MORGAN AND MORECAMBE OFFSHORE WIND FARMS: TRANSMISSION ASSETS

Works Plans - Onshore and Intertidal – Part 1 of 2

7 July 2025
Rev: F03

PINS Reference: EN020028
APFP Regulations: 5(2)(j)
Document reference: B8/F03

- Adjacent Sheets
- Order Limits
- Local Planning Authority Boundary
- 17A
- 17A19B
- 17B
- 17B19A
- 18A
- 18B
- 19A
- 19B
- 19A19B
- 34A
- 34A34B
- 40A40B
- 35A35B

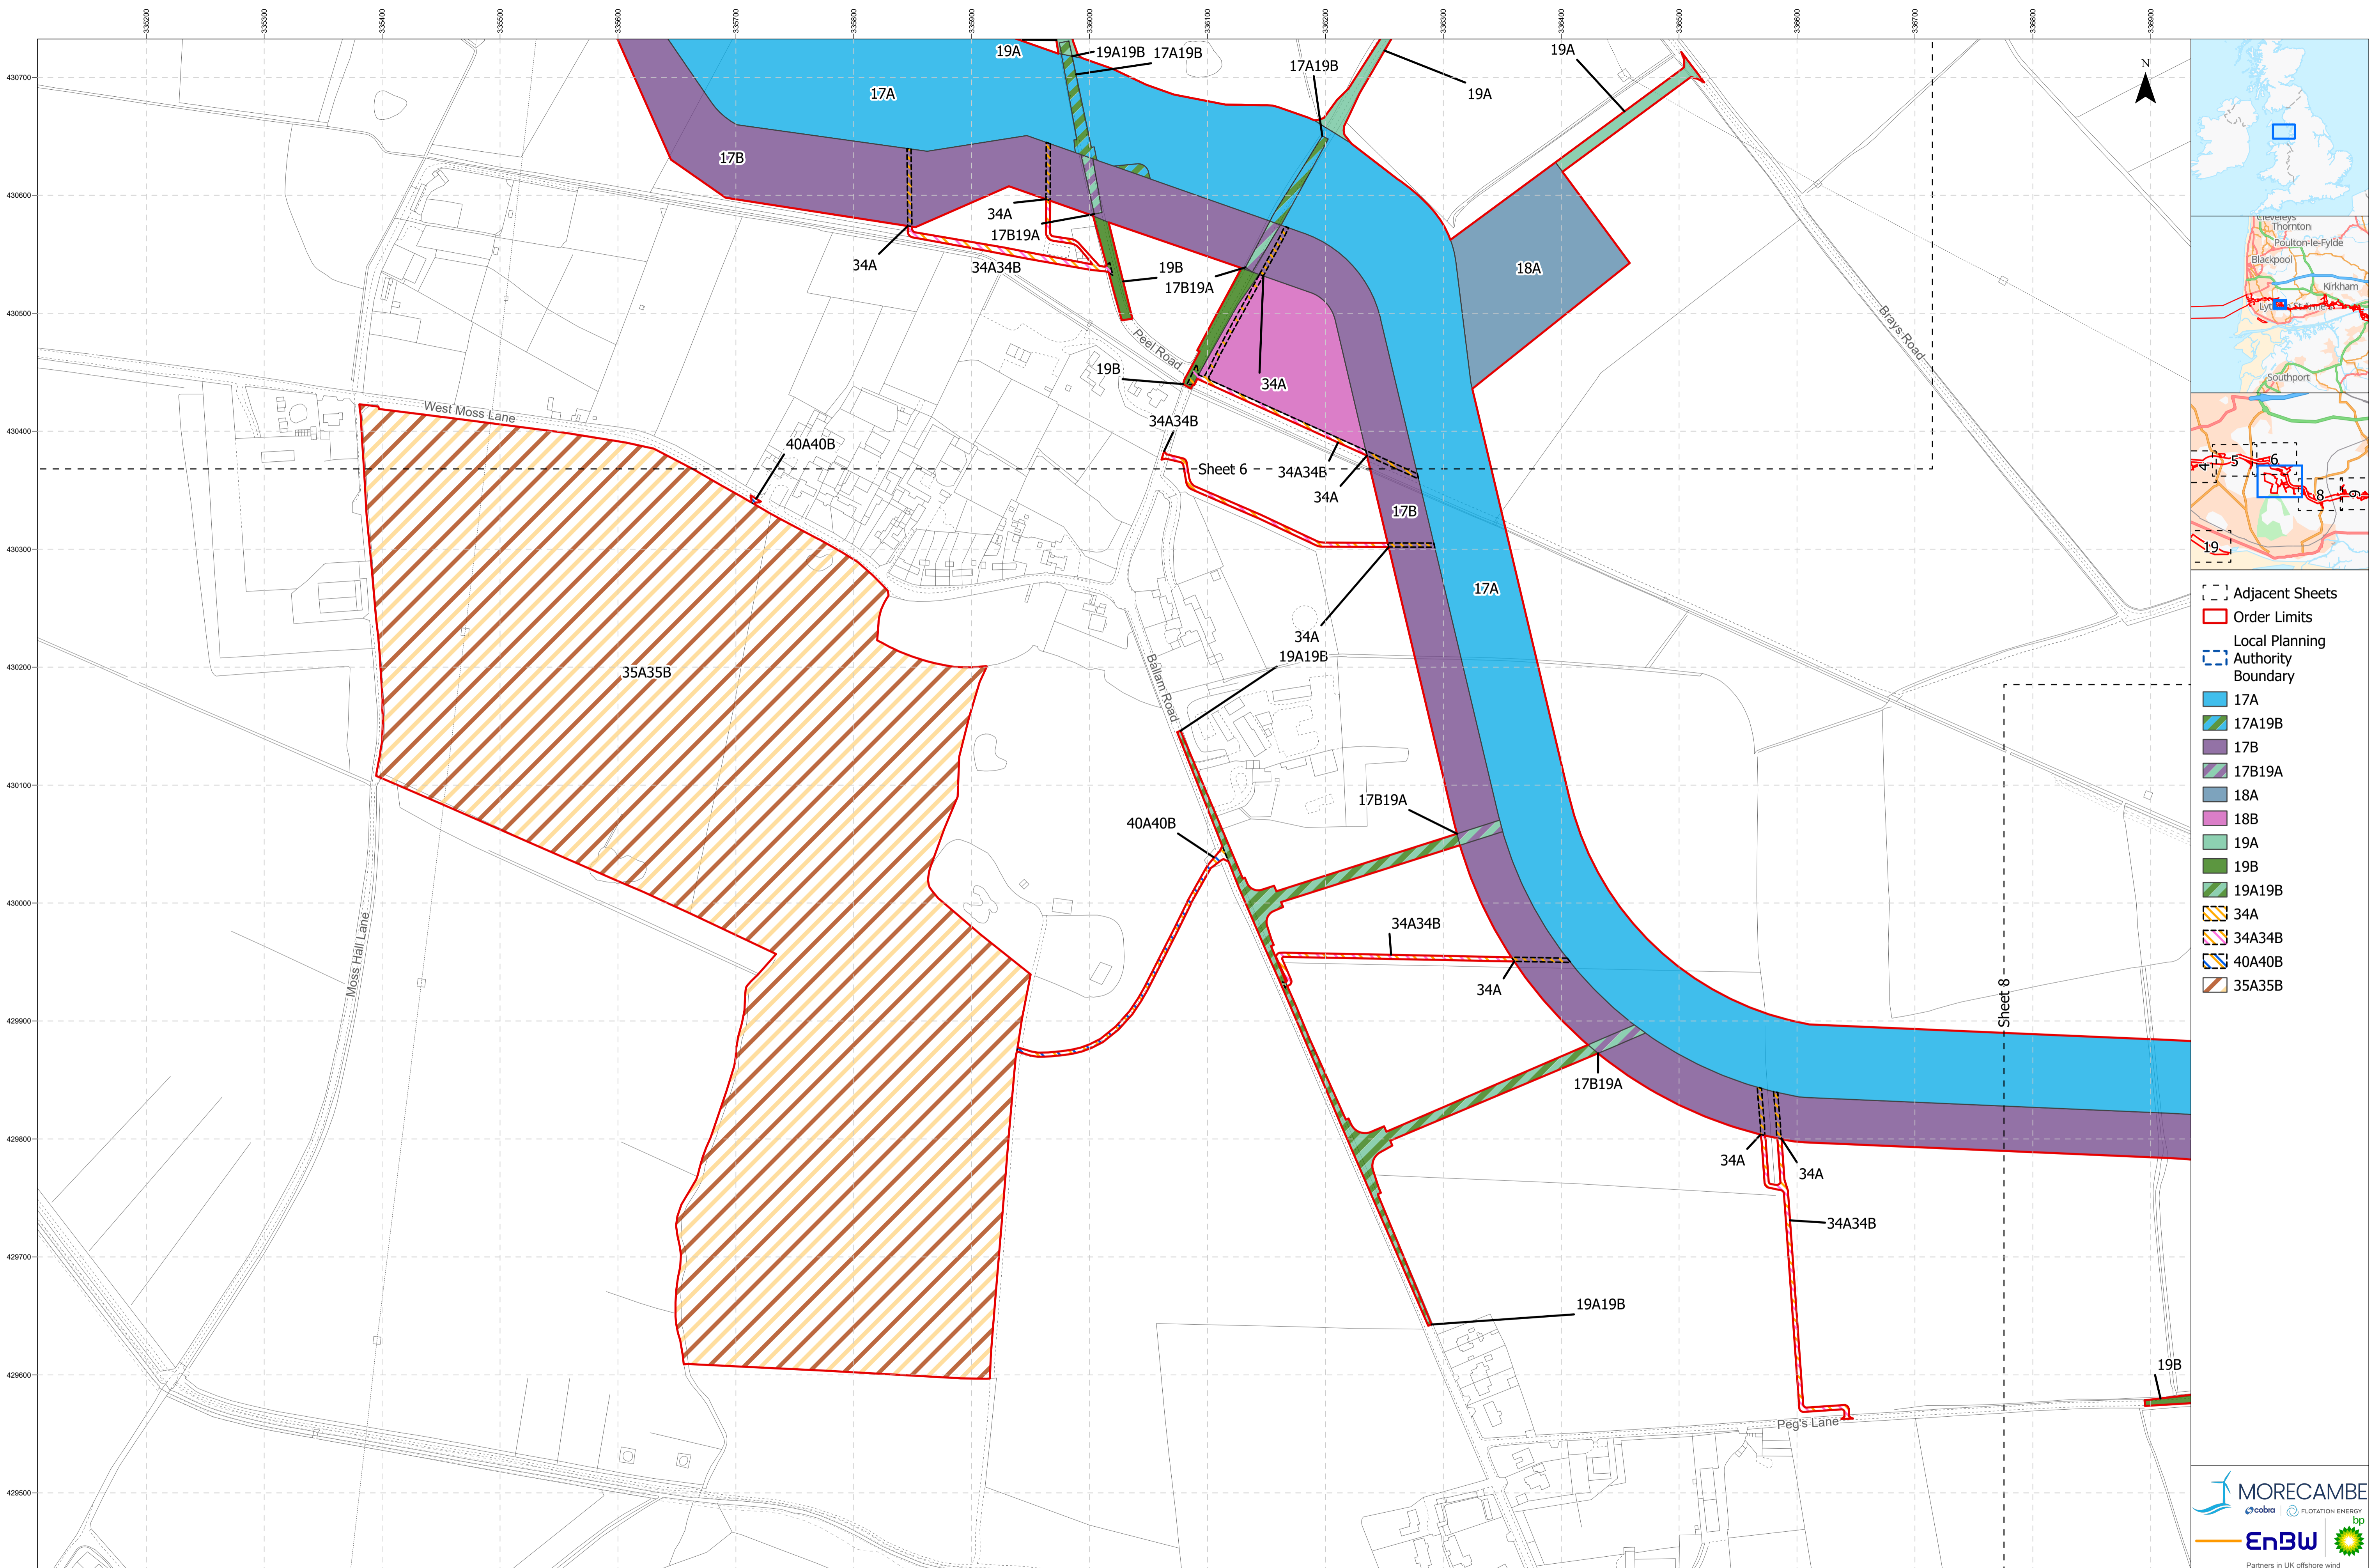
8	The Applicants	Construction access to environmental mitigation works (Work No. 40A40B) has been removed, south of Cartmell Lane.	<p>A review of the works plans identified that construction access to environmental mitigation works (Work No. 40A40B) was not required at this location.</p>	F02	S51 advice update
9	The Applicants	Morgan construction and permanent access to environmental mitigation works (Work No. 40A41A) has been remove off Cartmell Lane.	<p>A review of the works plans identified that construction and permanent access to environmental mitigation works (Work No. 40A41A) was not required at this location.</p>	F02	S51 advice update
